DUAL KEY OCCUPANCY AND THE IMPACT ON DEVELOPMENT CONTRIBUTIONS FOR THE KINGSCLIFF RESORT

Prepared for Leighton Properties

07 December 2010

1 B2 FLOOR PLAN
1:50

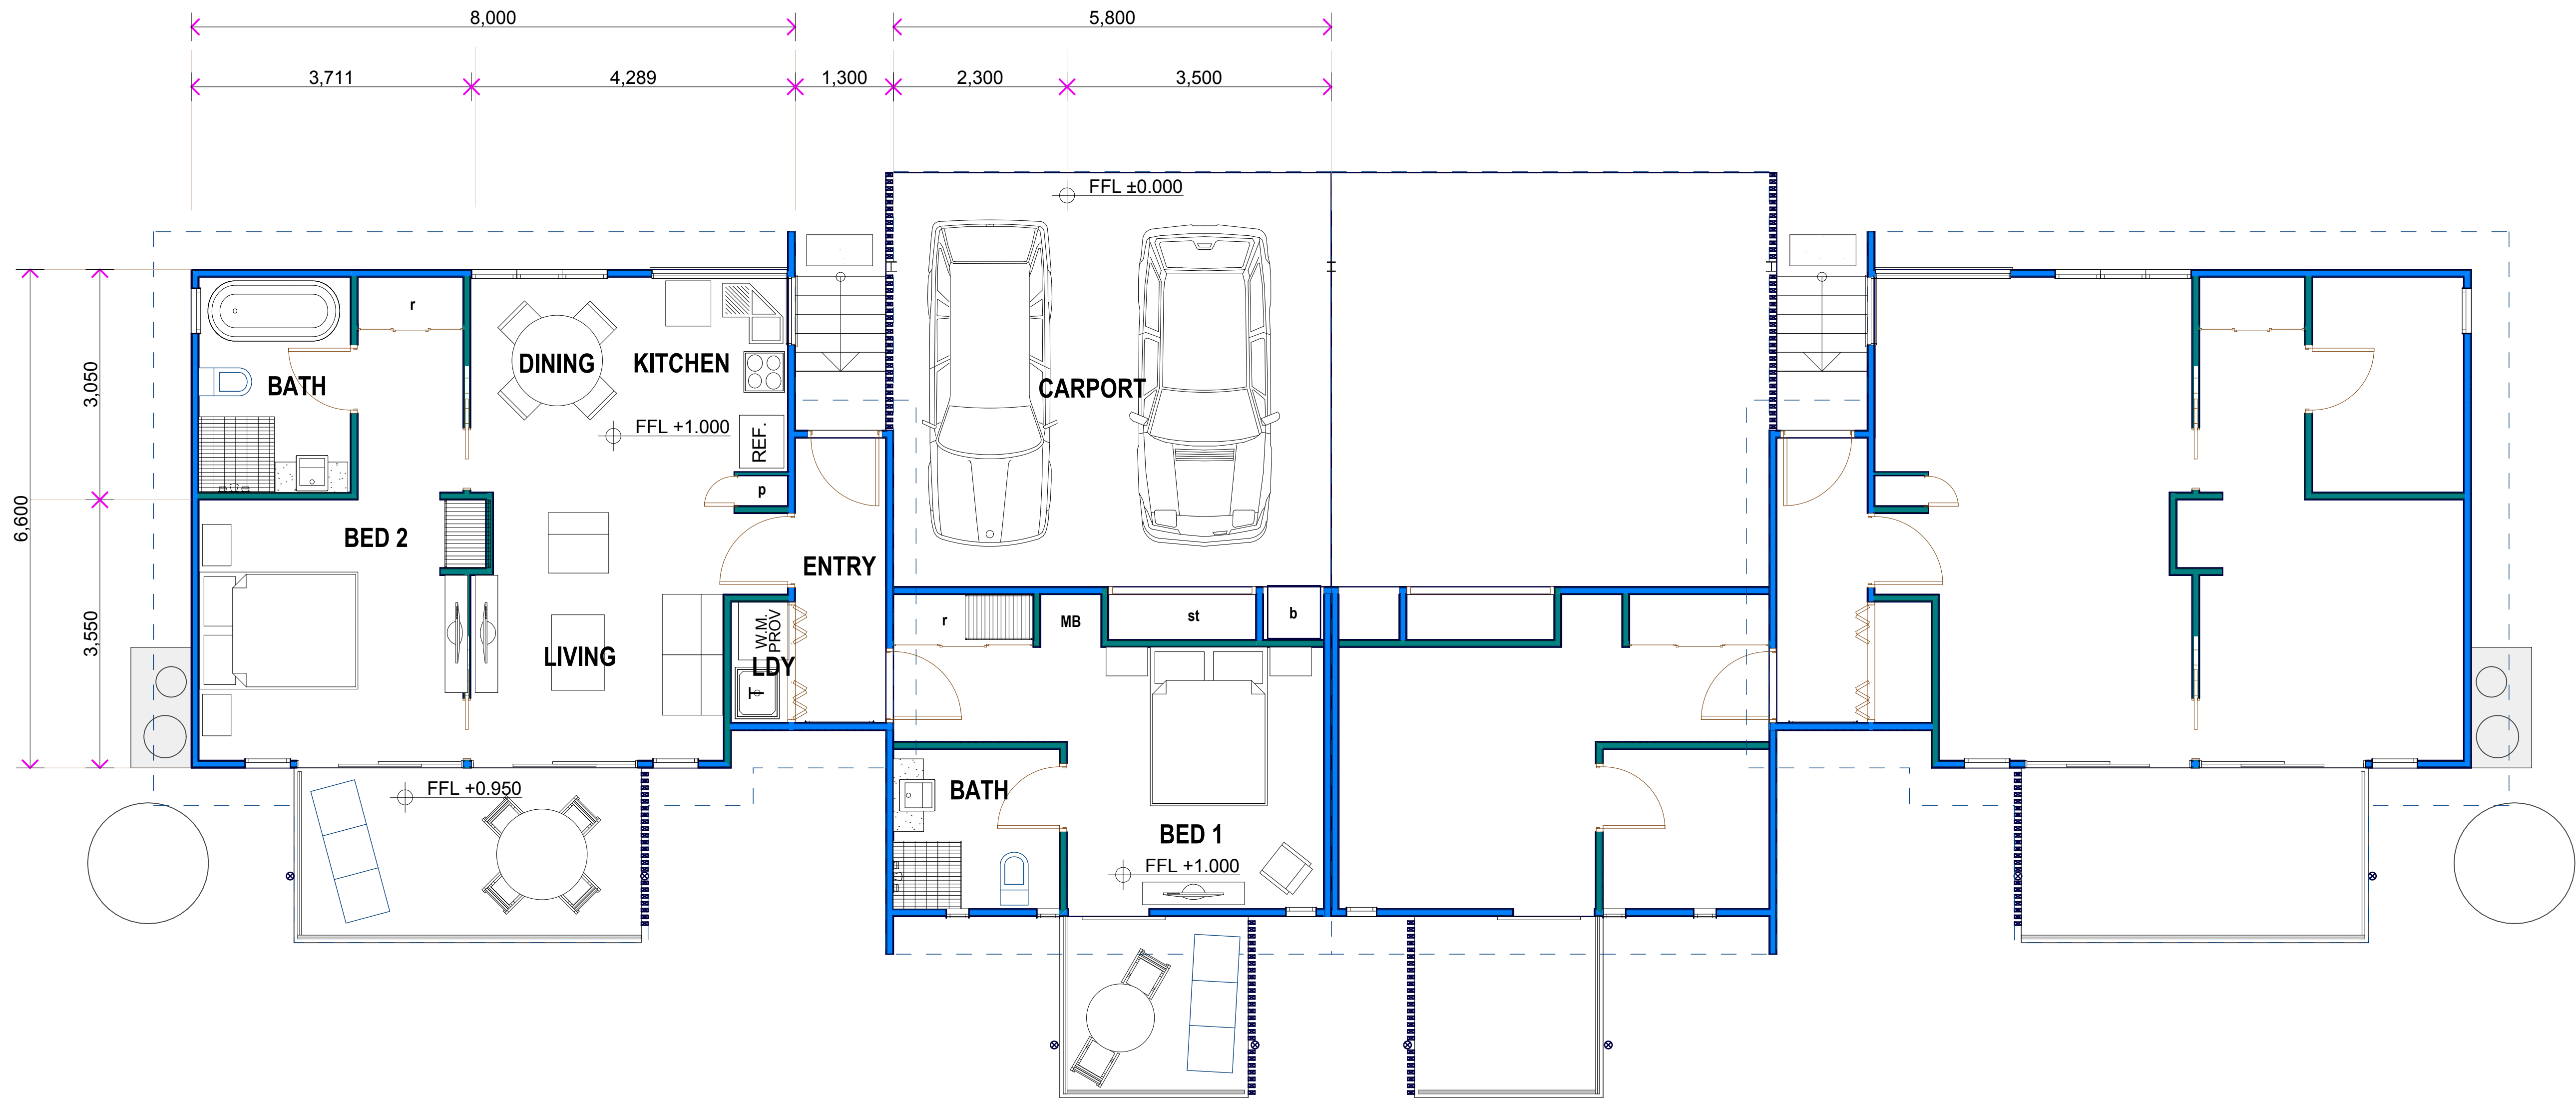
Following a review of the attached floor plans of the proposed 2 bedroom bungalows and 2 bedroom units, we do not consider the additional flows from bedroom no.2 to be comparable with that of a complete 1 bedroom unit, due to the proposed floor plan layout as detailed below:

- Bedroom 1 has access to a bathroom no.1, kitchen and living areas;
- Bedroom 2 has access bathroom no.2.

Whilst the second bedroom has a separate access and key, it is important to note that demand (for water, sewerage and community facilities) is driven by the number of people occupying the unit. This is unlikely to be significantly impacted if the bungalow has one or two keys.

From a water and sewerage perspective, the major sources of demands will be the shower, toilet and laundry. Given that there is only 1 kitchen and laundry, each bungalow has no additional fixtures to a normal unsuited 2 bedroom unit. It is unlikely that the demand would differ substantially if the bungalow was rented to two separate parties or just one and as such it is considered that the Development Contributions should not differ to those of a 2 bedroom unit.

- The number of fixture units is unchanged whether there is a dual key arrangement or not;
- Based on the plans supplied, there are 13 fixture units per dwelling, which represents a loading of approximately 0.7ET.

A more reasonable assessment would be to consider the unit / bungalows as 2 bedroom units with a loading of 0.7ET. This is consistent with how the units would be assessed under various other policies in NSW.
